Application Reference: 2026/0371

Site Address: 2 Kensington Road, Old Town, Barnsley, S75 2TX

Proposal: Erection of two storey side extension, single storey rear and side extension and single storey front porch.

Proposed Elevation - A (1:100)

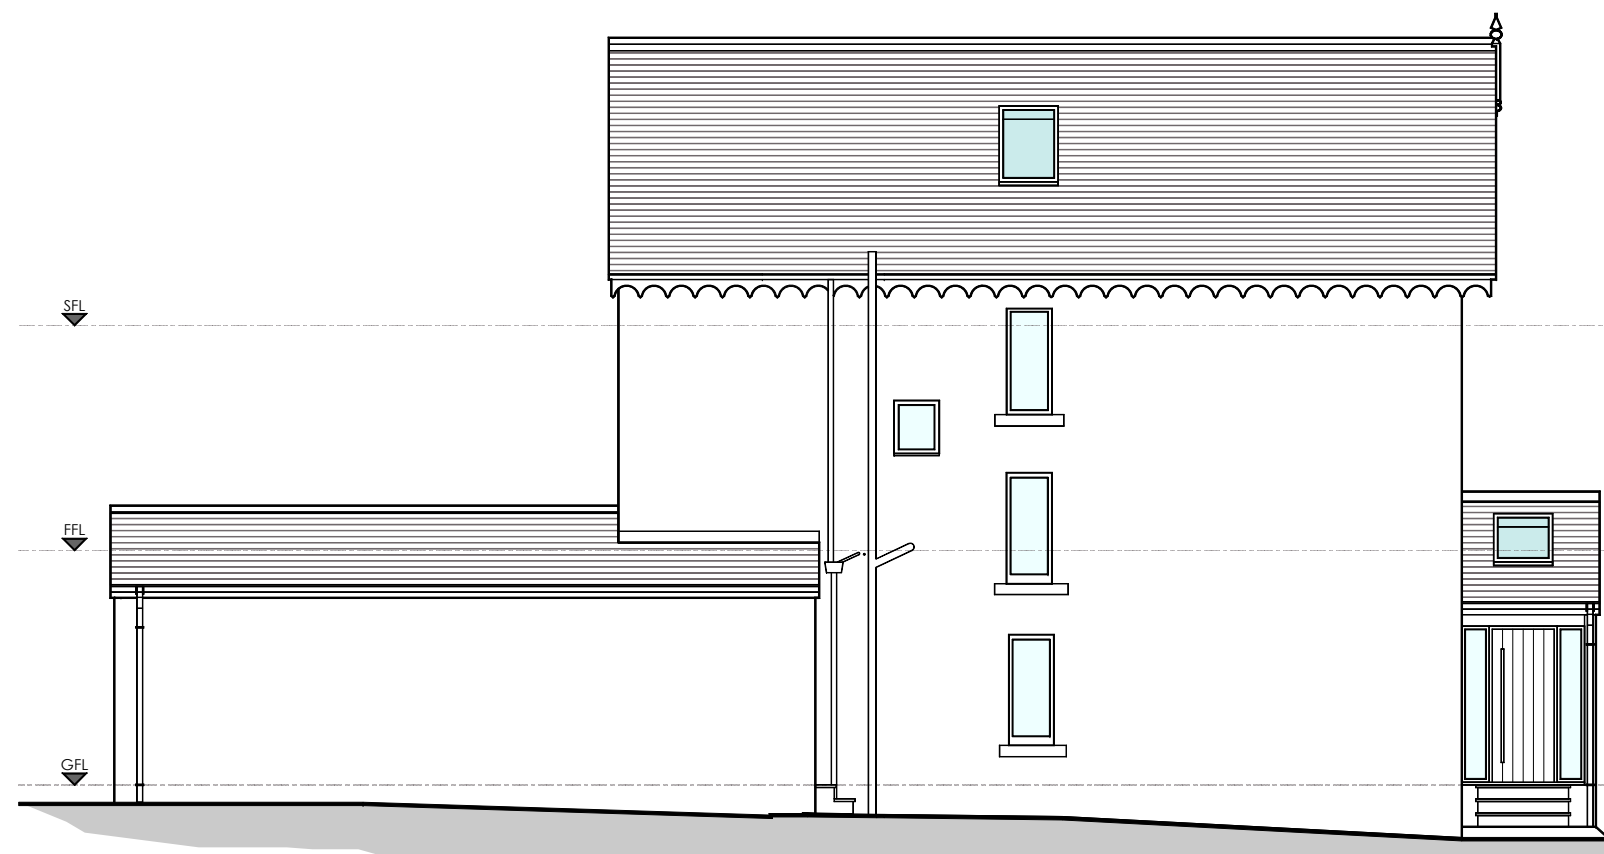
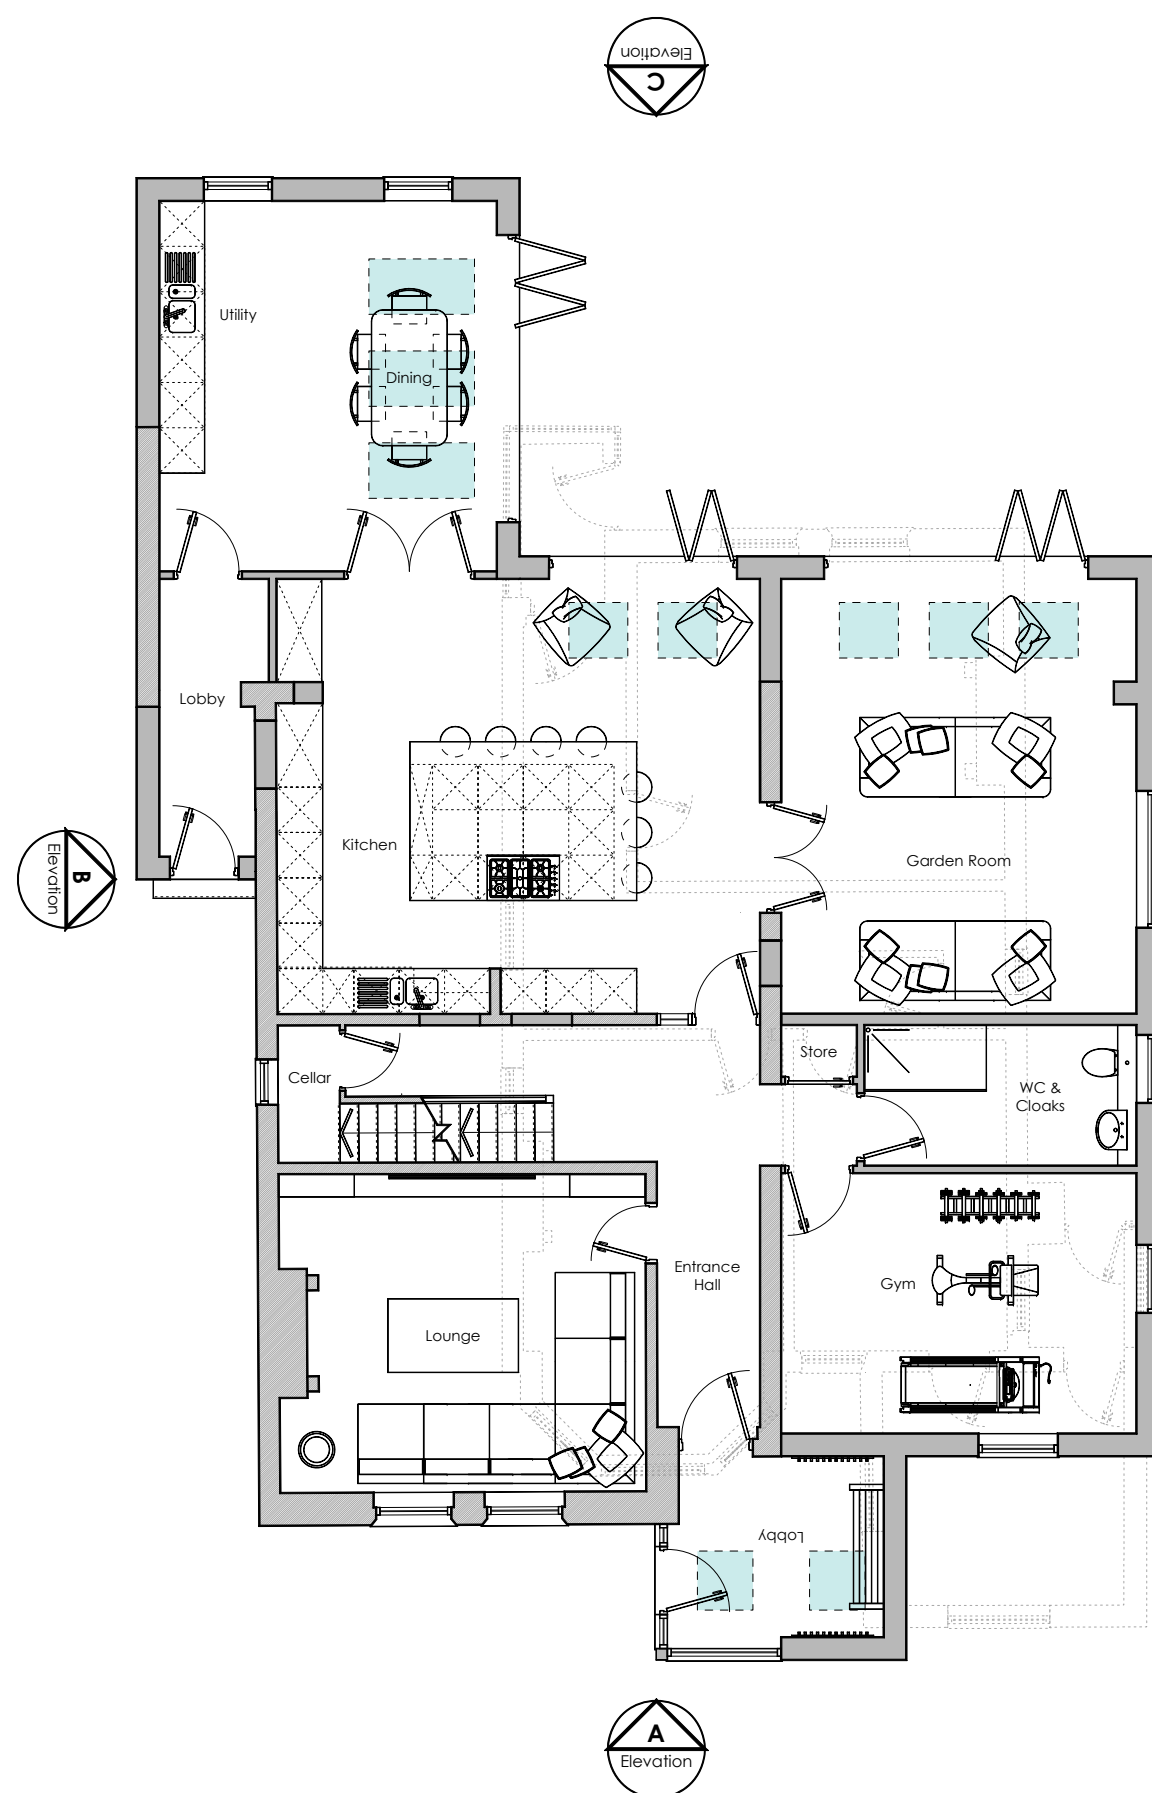
The existing dwelling has unusual proportions having a narrow and tall appearance with high eaves within a large plot. The proposed side extension is noted to provide a projection greater than two thirds the width of the existing dwelling by approximately 0.5 metres. In addition, there is no set back or step down proposed. However, in this case, the width of the sideways extension and the omission of the set down/step back allows a simple roof design results in a dwelling of more balanced proportions than existing, which when considered together with the substantial size of the plot and side garden, is considered acceptable when viewed from the streetscene. A significant gap is retained between the side elevation of the proposal and the nearest neighbouring property resulting in no possibility for a terraced effect.

The proposed front, porch extension would provide a moderate forward projection of approximately 2.7 metres on the west of the front elevation and 1.8 metres on the east of the front elevation. Given a porch is existing, the proposed extension would only extend further forward by approximately 0.4 metres which is considered an insignificant addition. The proposal would provide an improved roof design over the current porch extension which resembles a small conservatory and is contrary to the current House Extensions SPD.

Proposed Elevation - B (1:100)

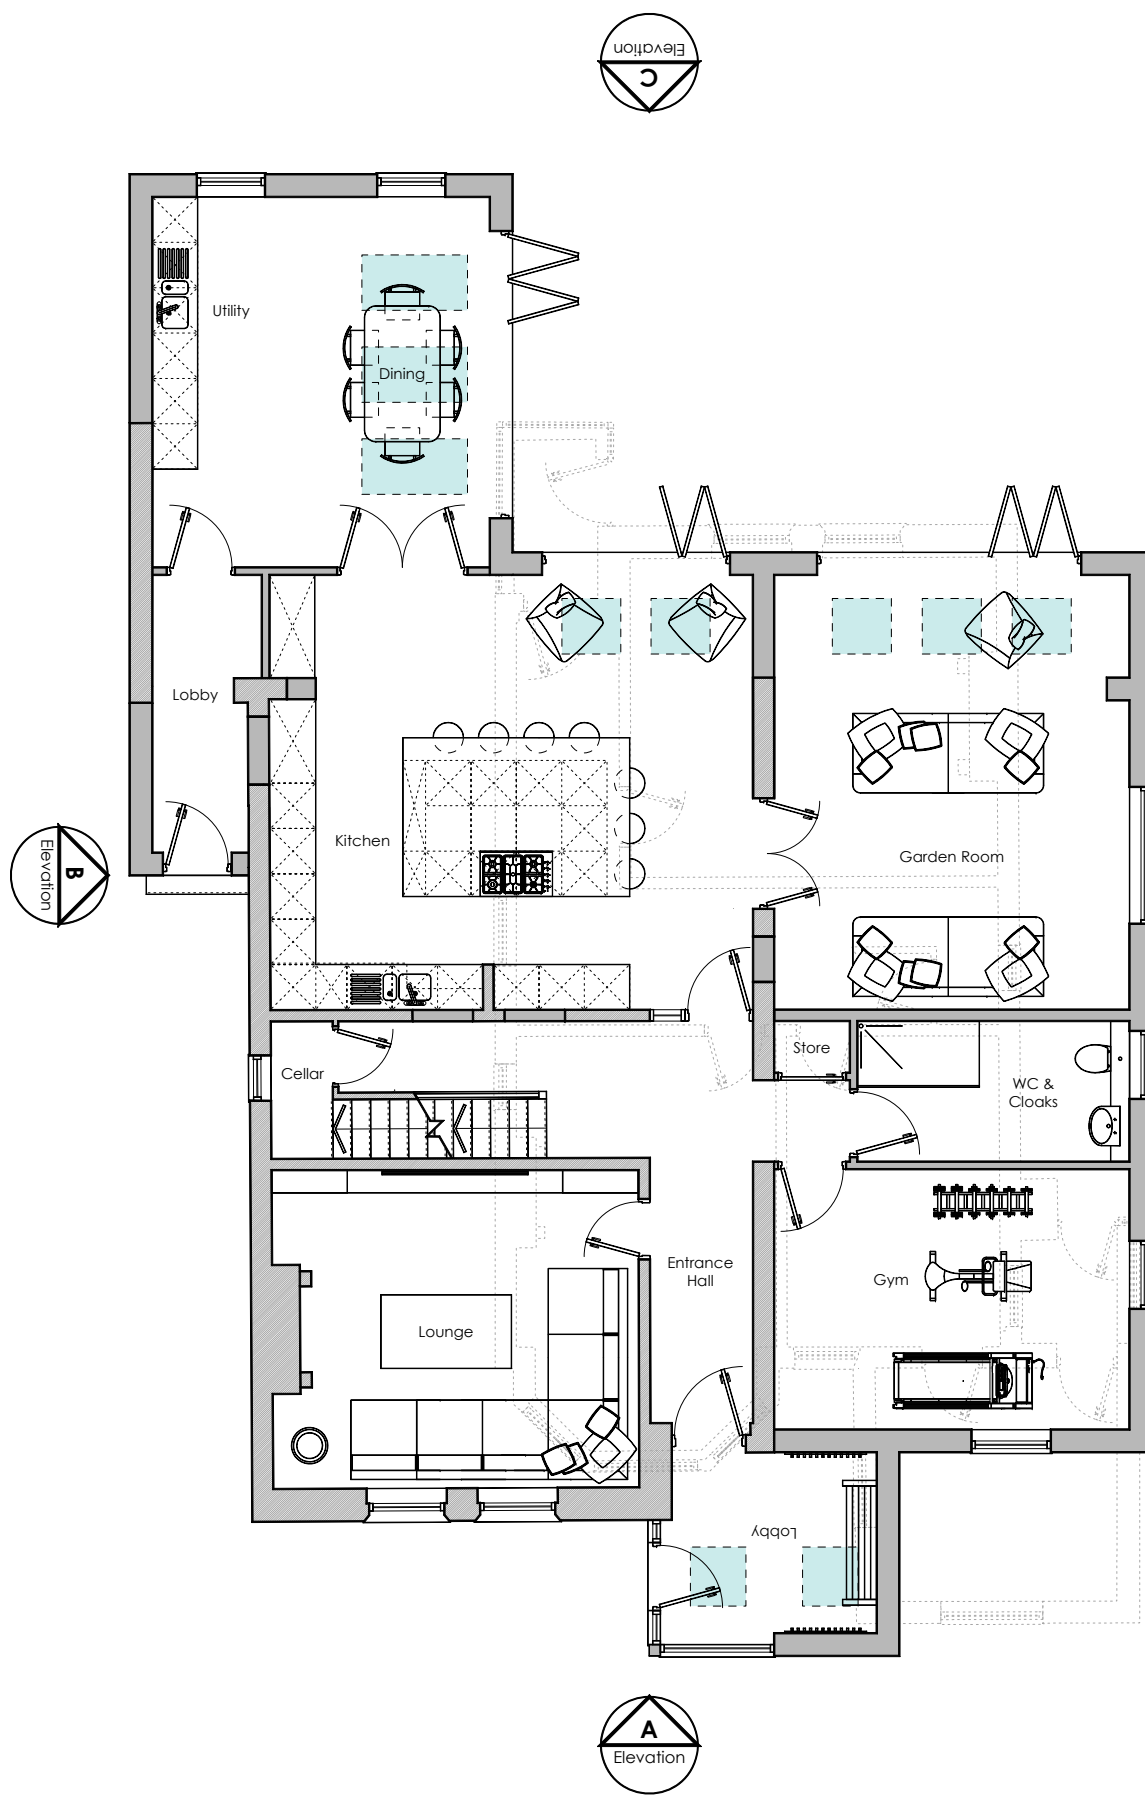
Clarification was sought as to whether the applicant intended to replace the removed trees. It was confirmed the applicant would be redesigning the garden once the proposed extensions were complete. An amendment was requested and provided on the 27th August 2026 to include the second-floor bathroom window on the proposed side elevations.
